CHRIS TEAM SUBDIVISION

FINAL DRAINAGE REPORT

ALL TERRAIN ENGINEERING PROJECT NO: 24019

AUGUST 2024

EXISTING CONDITIONS DRAINAGE MAP

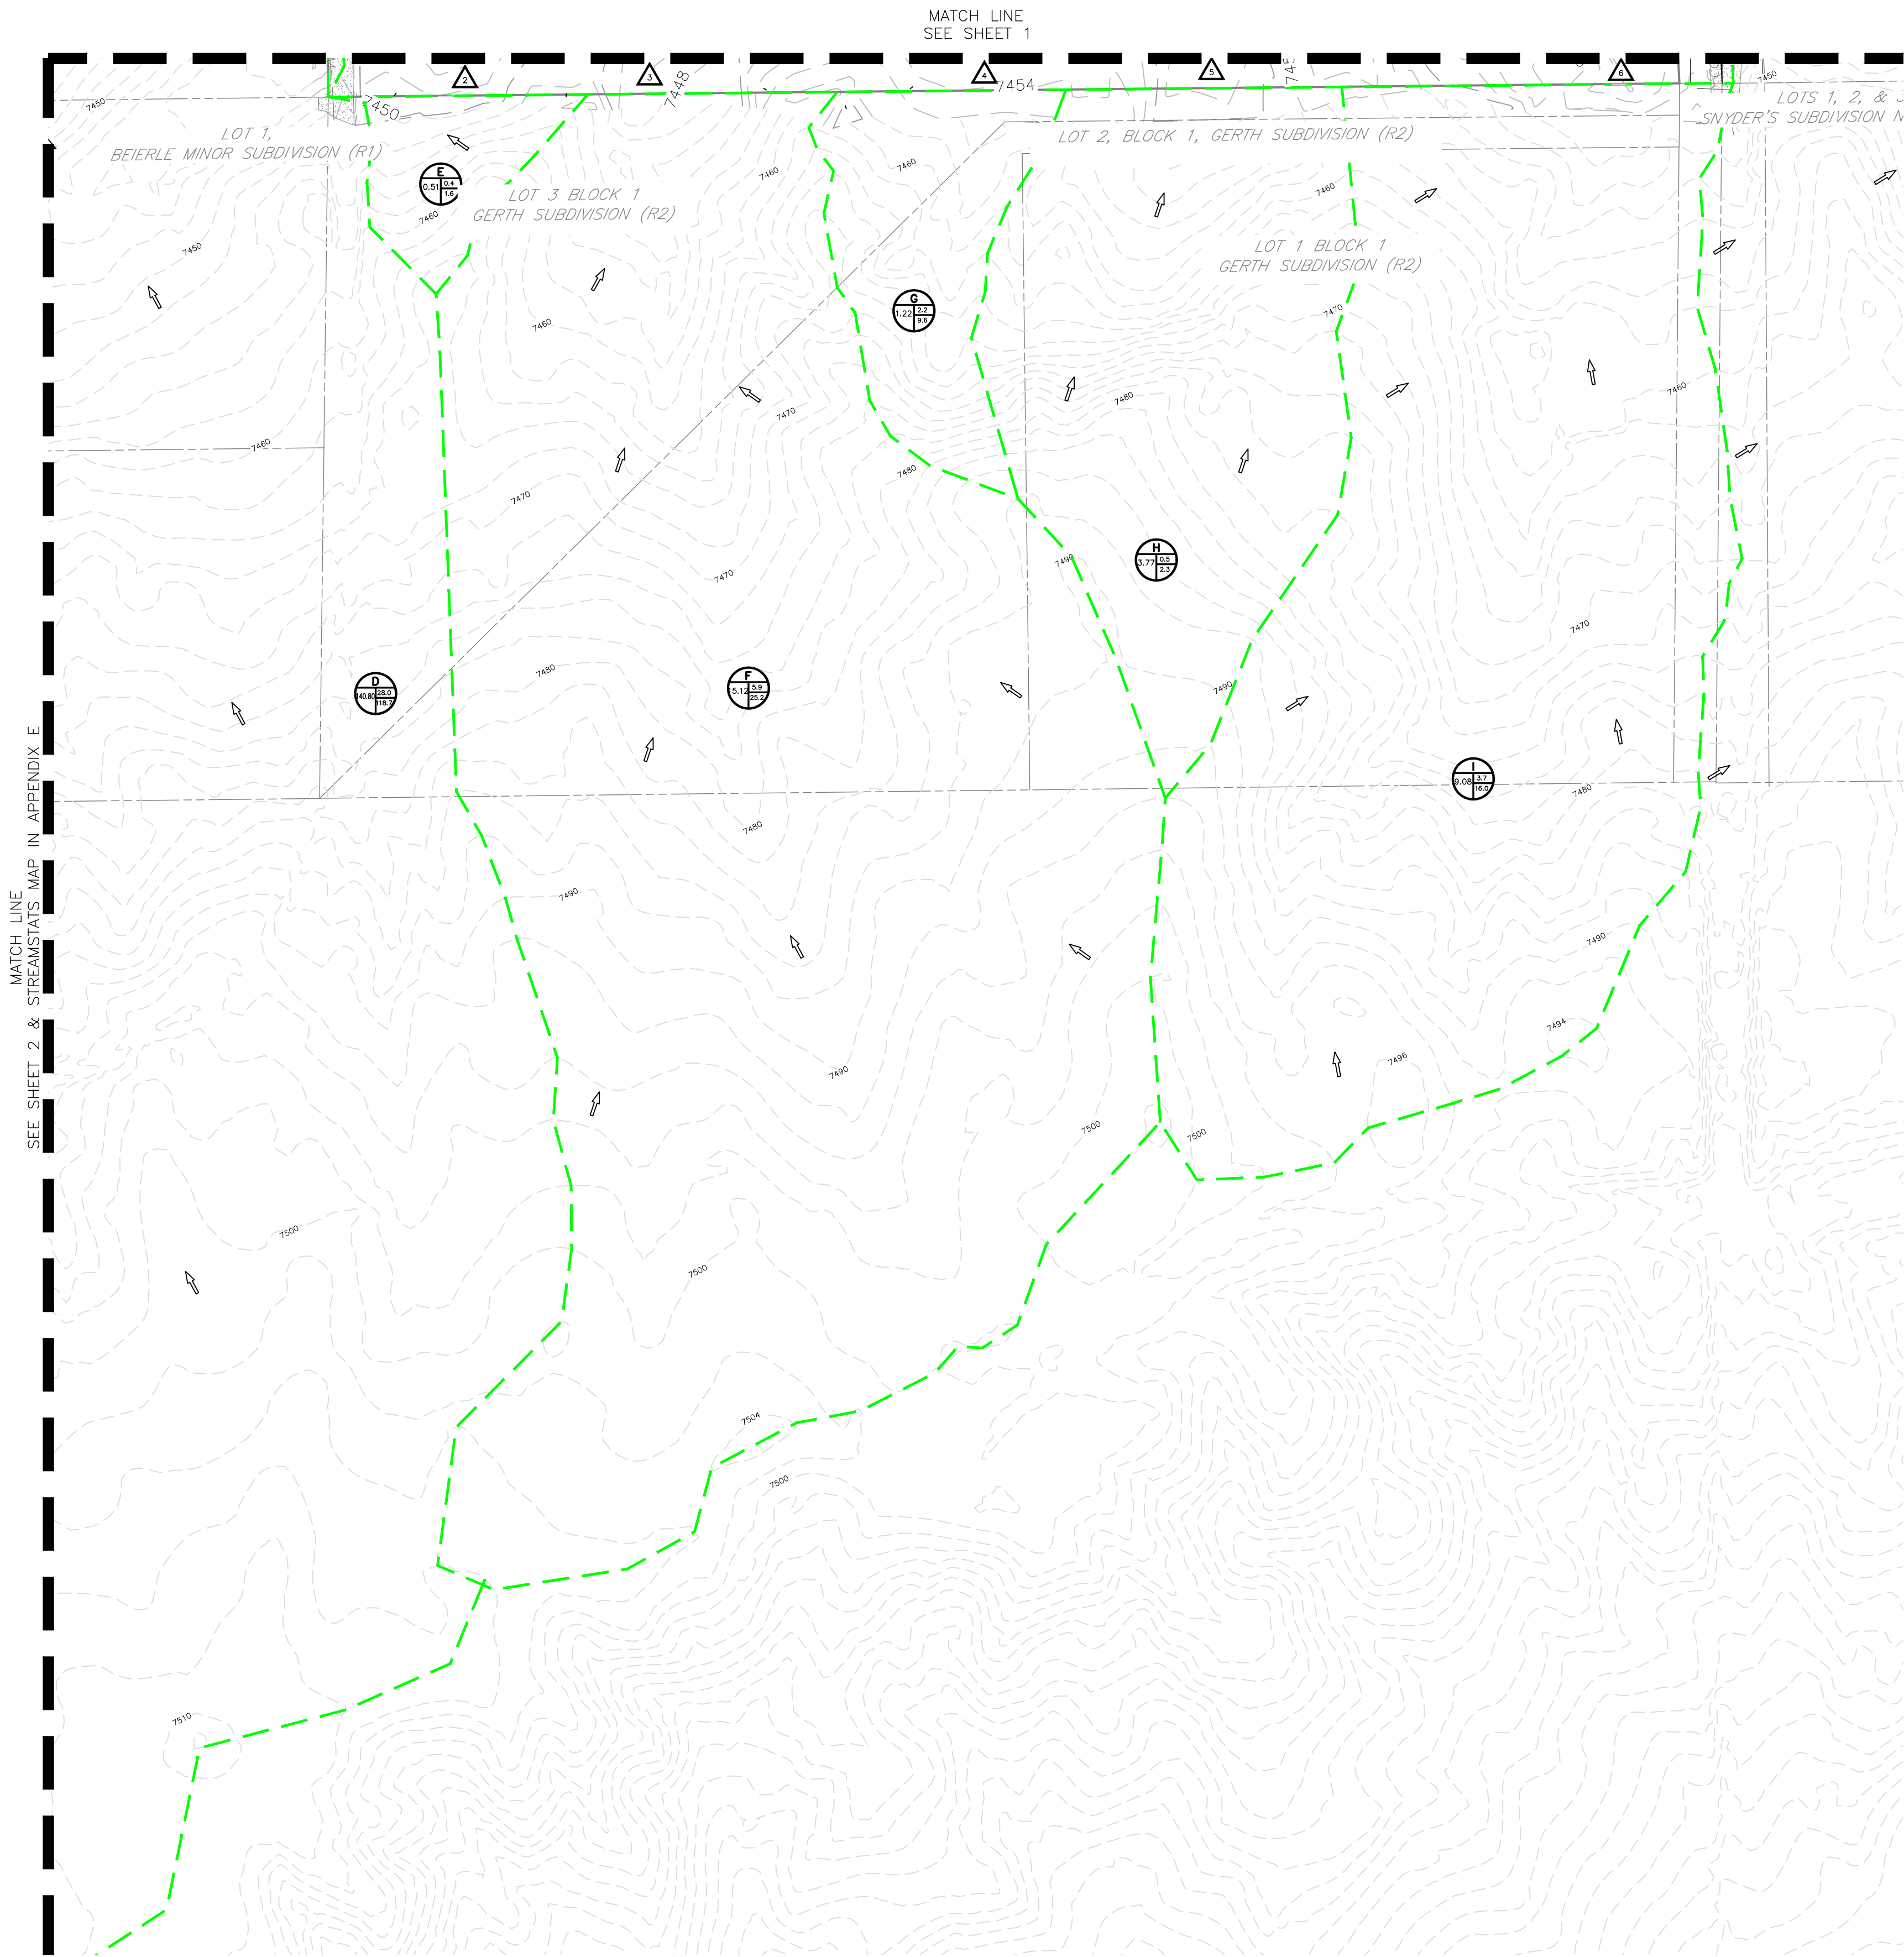
Include a discussion of the existing 12" culvert at the NW corner of the site, as shown on the drainage map

Provide a basin and description for offsite flows from the south of the project site

ATE RESPONSE: ADDRESSED. PLEASE REVIEW BASIN C DESCRIPTION AS THE CULVERT IS LOCATED WITHIN BASIN C.

ATE RESPONSE: ADDRESSED. SEE BASIN D DESCRIPTION.

PROPOSED CONDITIONS DRAINAGE MAP

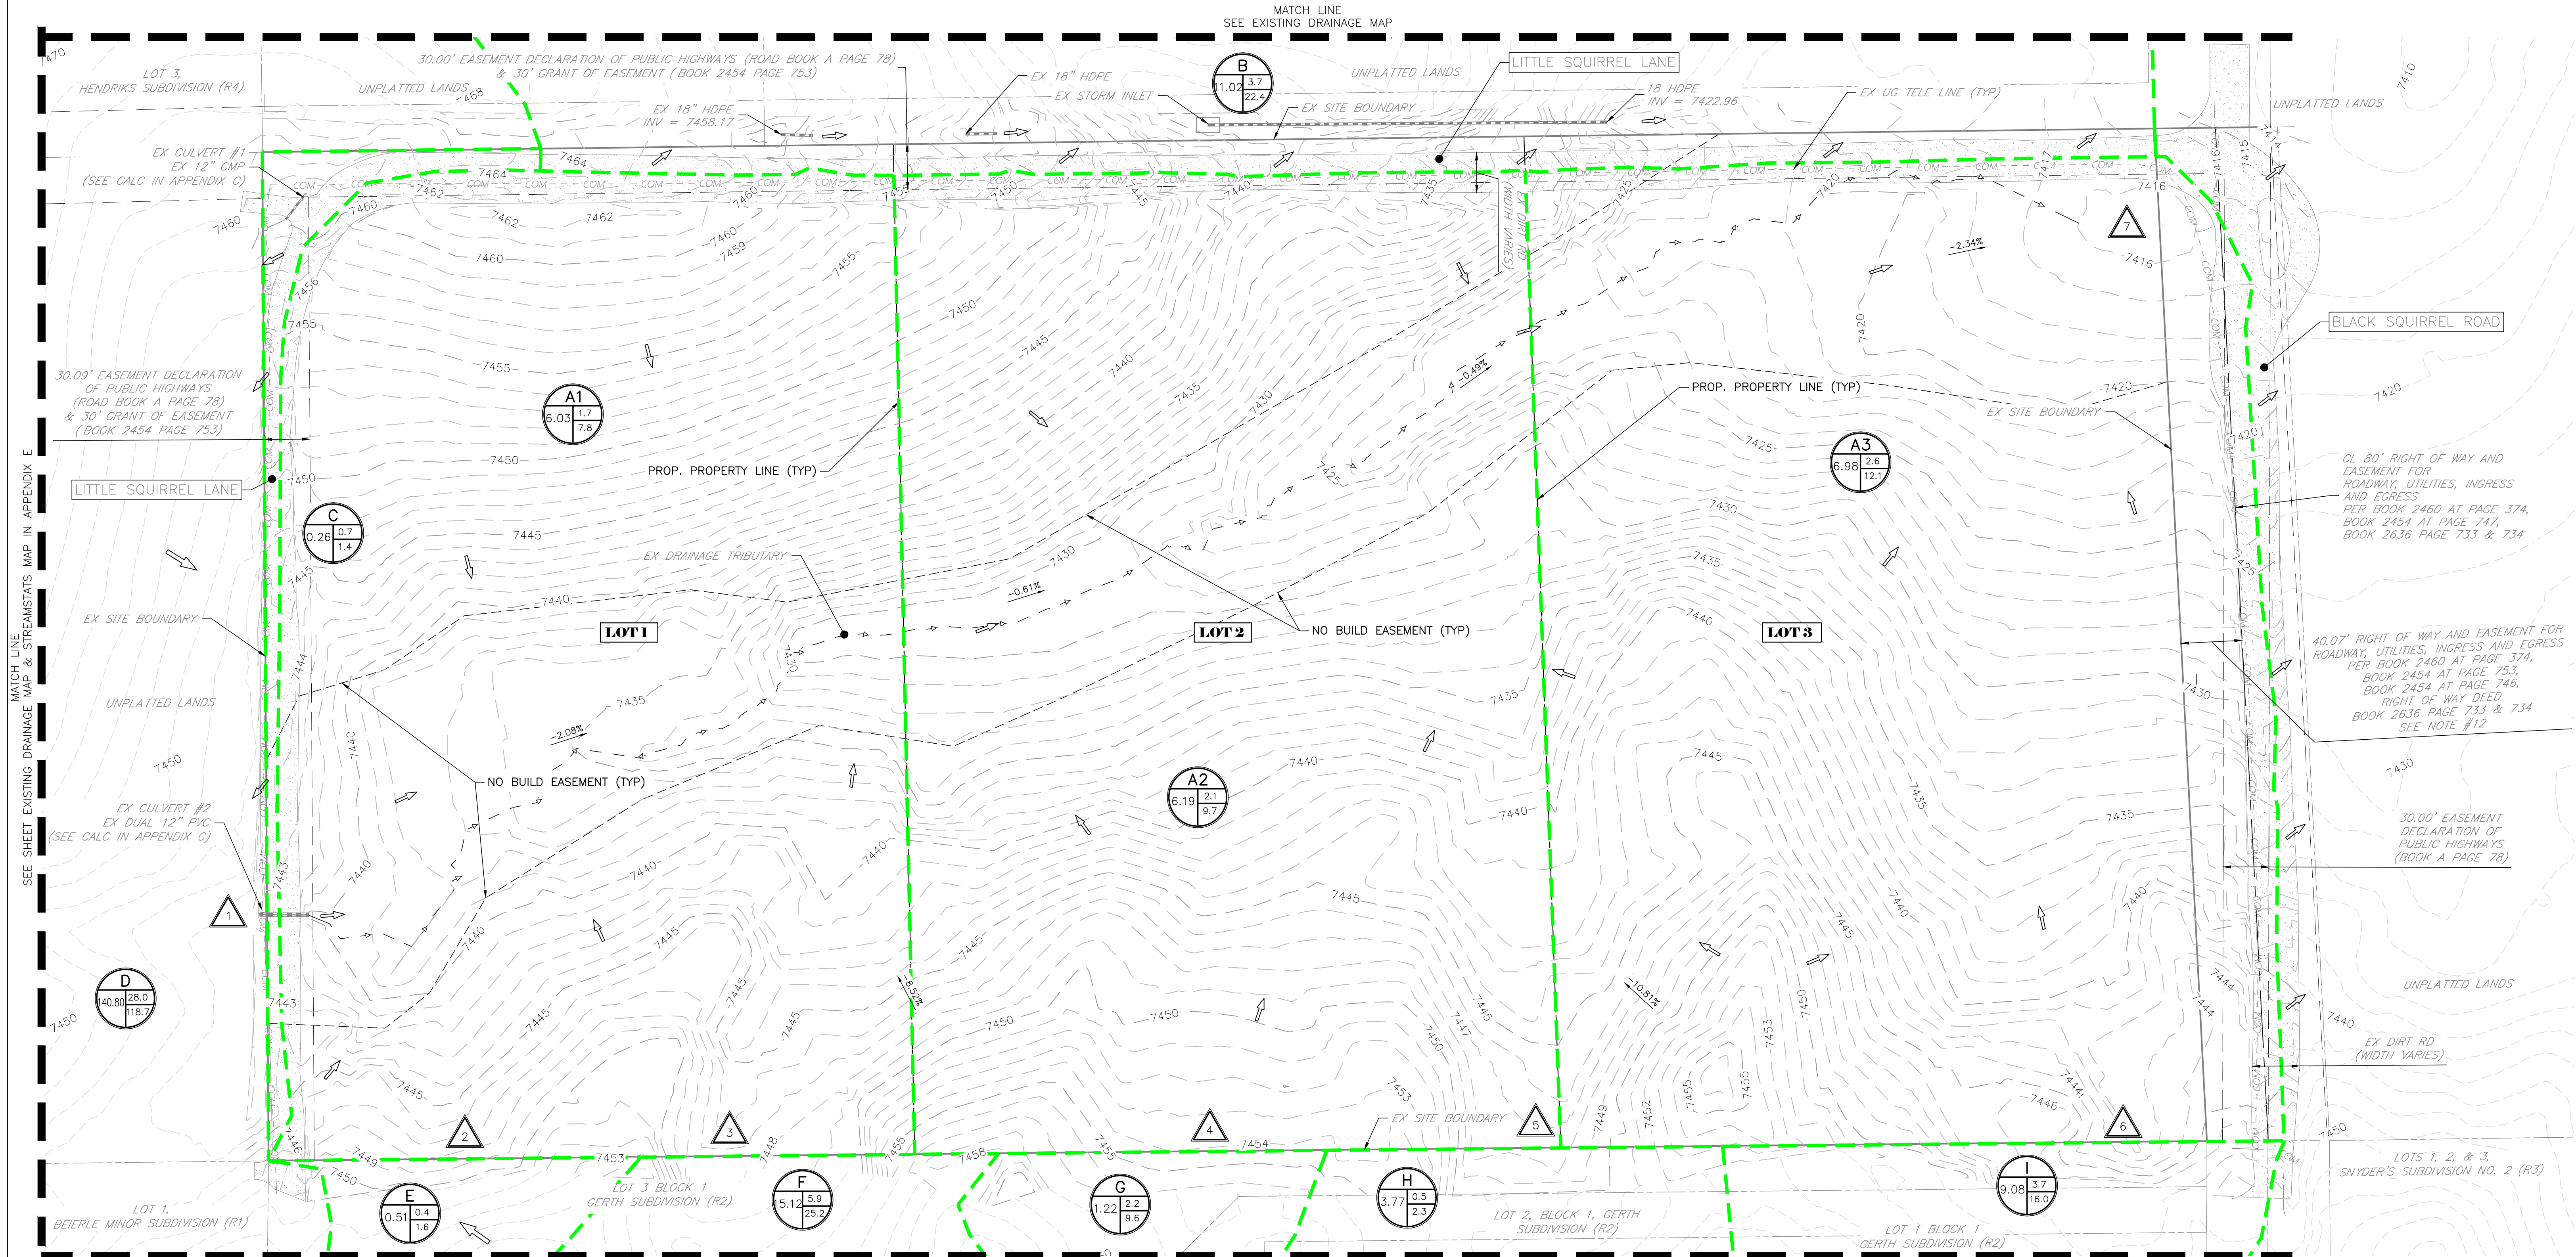
Will still need to assume an increased imperviousness for future home and driveway and what those increase in flows will be.

ATE RESPONSE: ADDRESSED. SEE REVISED TEXT.FOR BASIN A.
